Your Ref :
Our Ref : AW/92/13/NMA

Application for a non-material amendment following a grant of planning permission AW/165/12 -
change timber cladding to smooth render to match existing ground & first floor & side & rear
elevations
3 Selsey Avenue, Aldwick, ,

project:	Proposed Elevations		
address:	3 Selsey Avenue Bognor Regis West Sussex		
client:			
date:	November 2012		
drg. no.:	4454/8 A		
scale:	1:50		
revisions			
A	Timber Cladding Changed To Smooth Render To Ground And First Floor Extensions		April 2013

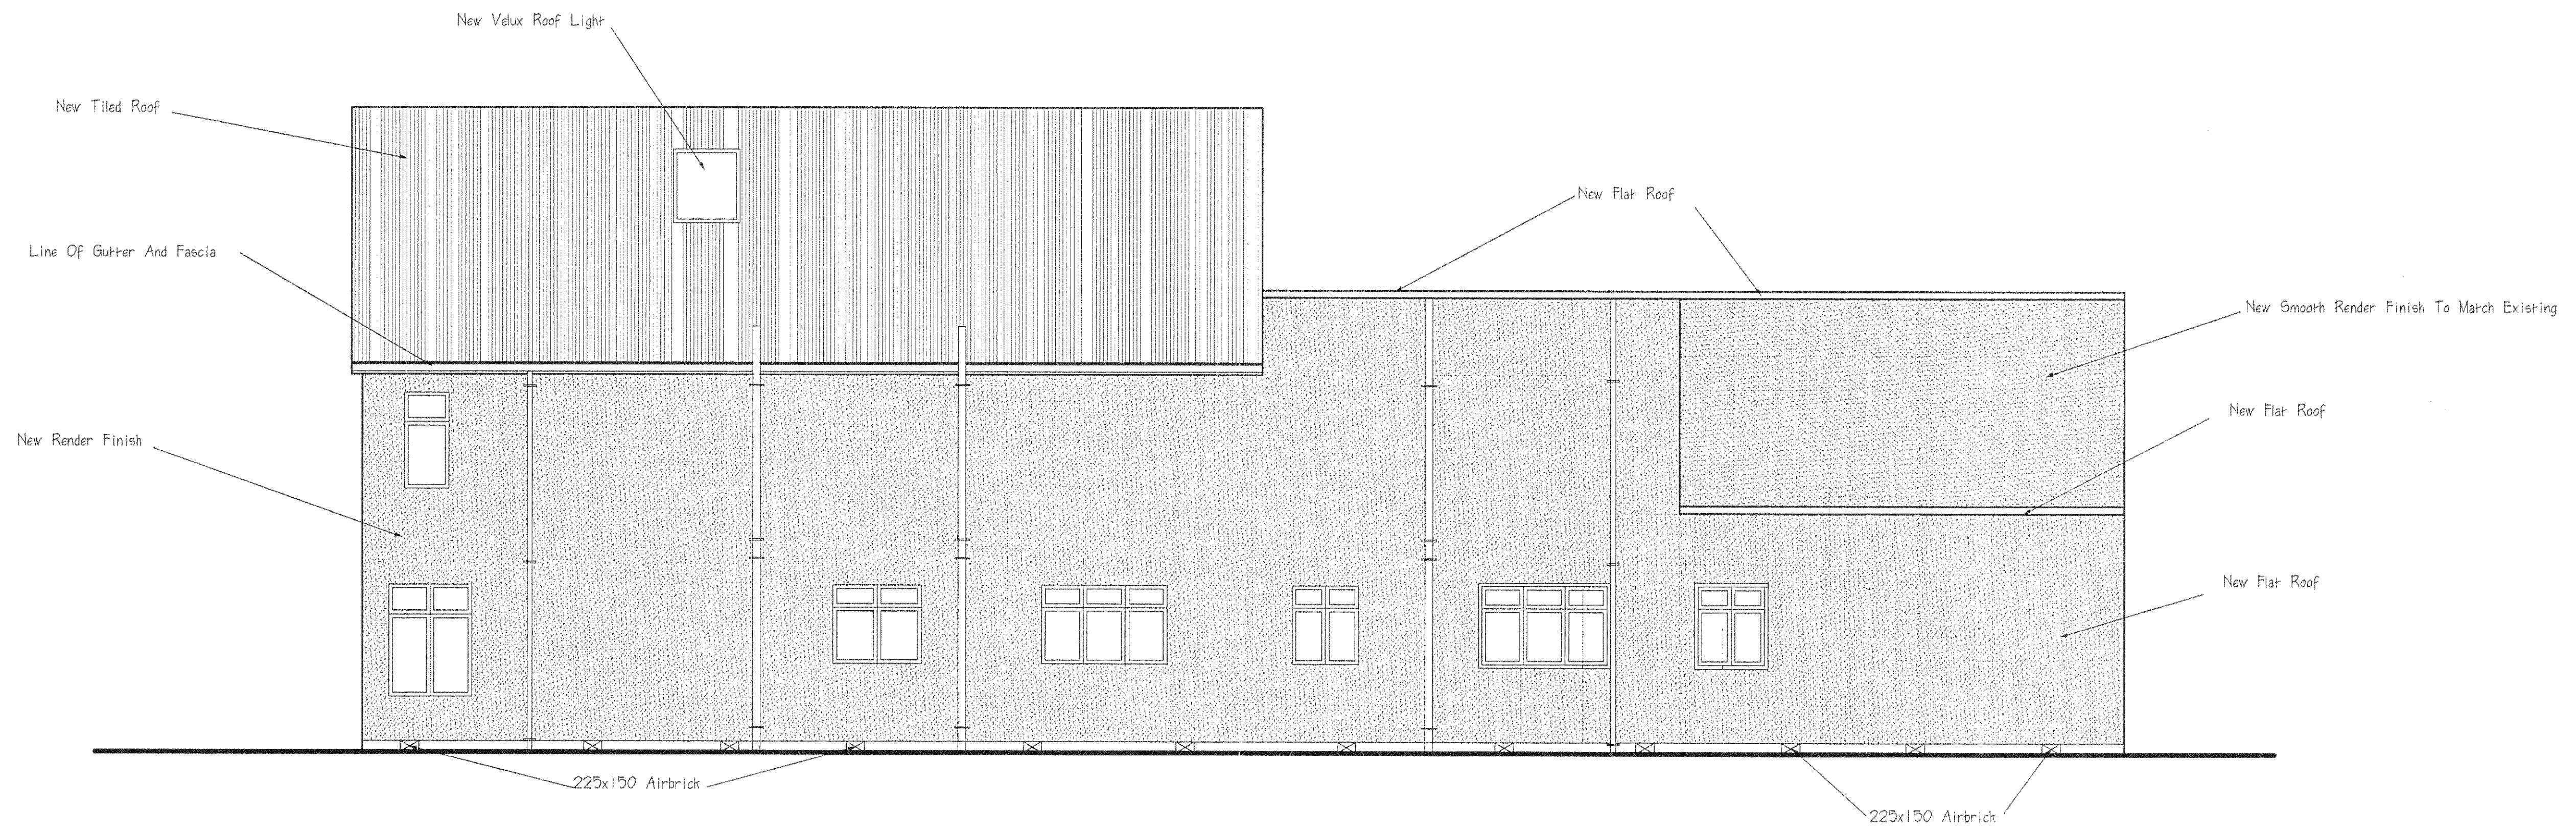
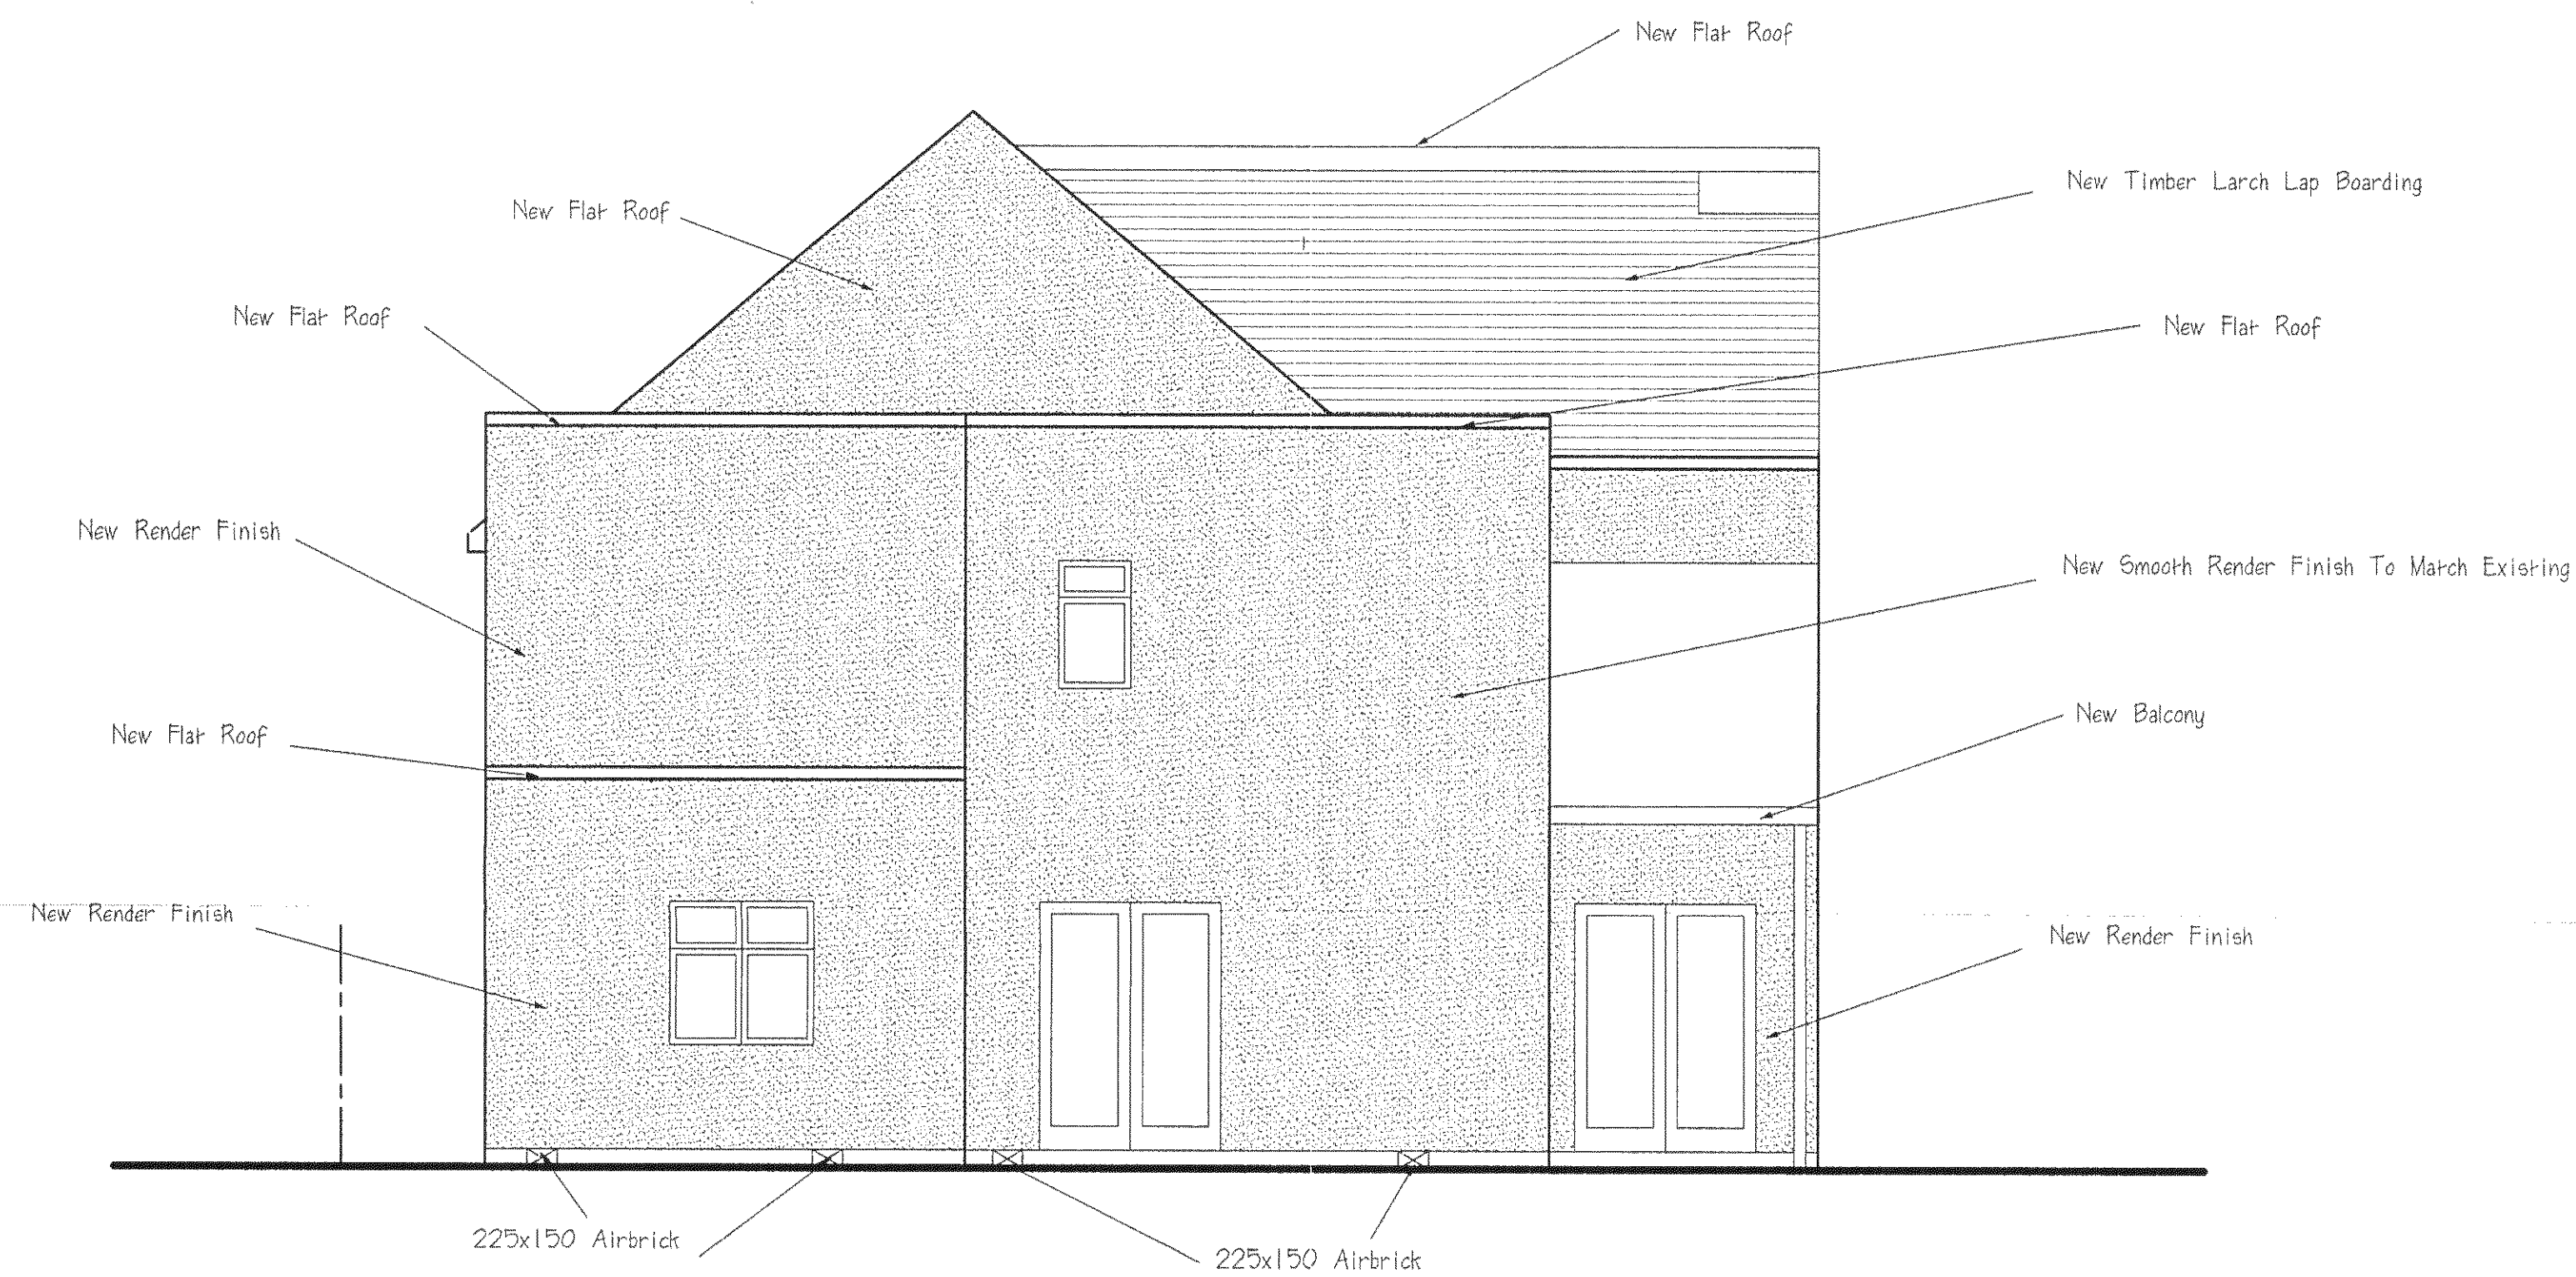
I refer to your recent application for a Non Material Minor Amendment. From the information submitted I am happy to take the alterations as a Minor Amendment to AW/165/12 for the change of the previously approved timber cladding to smooth render to match existing ground and first floor elevations.
